**WELWYN HATFIELD BOROUGH COUNCIL  
EXECUTIVE DIRECTOR - PLANNING, PUBLIC PROTECTION AND GOVERNANCE**

**Application No:** 6/2022/1990/PN6  
**Location:** The Rafter's Vineyards Road Northaw Potters Bar EN6 4PG  
**Proposal:** Prior approval for the erection of 8.5m x 6m private road access of the nearby farmland  
**Officer:** Ms Elizabeth Mugova

**Recommendation:** Prior Approval Required and Refused

PROPOSED SITE PLAN
 Scale 1:500 @A1

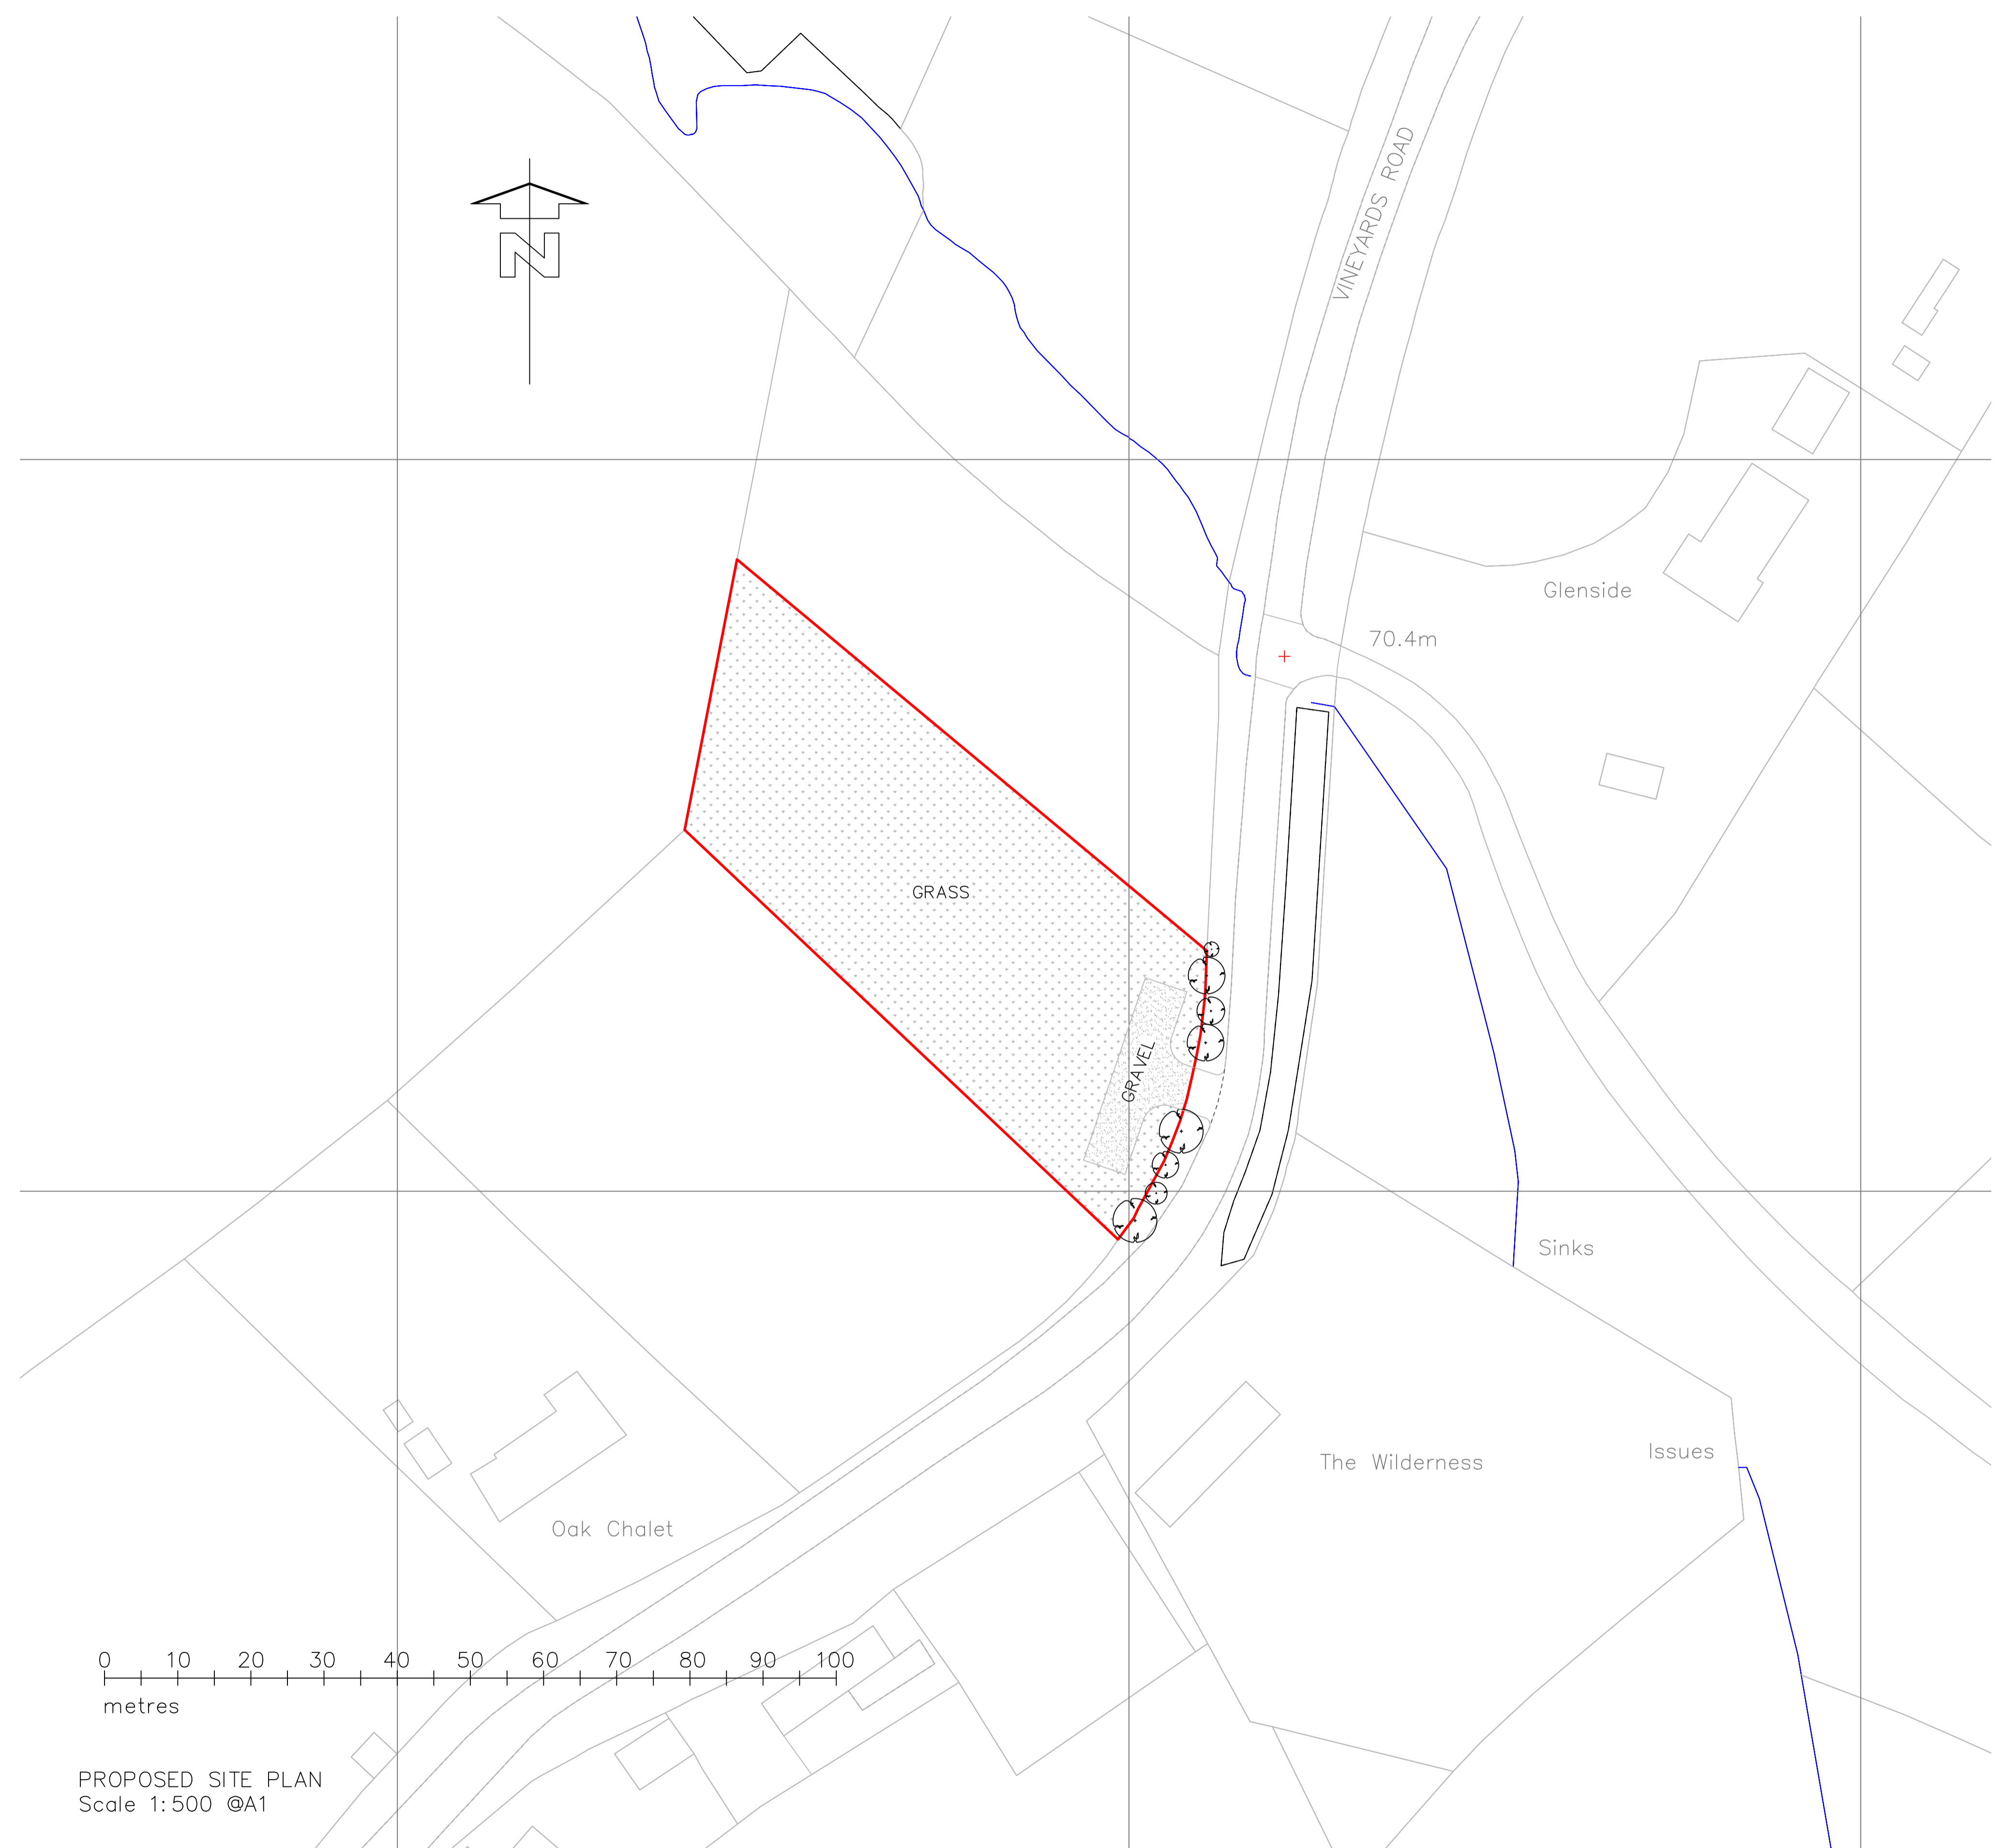
**The application site is less than 0.4 hectares in area.**

**The application site is currently open grassland and free from development, therefore, the external appearance of the site would be materially affected.**

**The development is within 25m of Vineyards Road which is a classified road.**

1. The proposal fails to meet the criteria of Schedule 2, Part 6, Class B.1 (a, b & c) of the Town and Country Planning (General Permitted Development) (England) Order 2015.
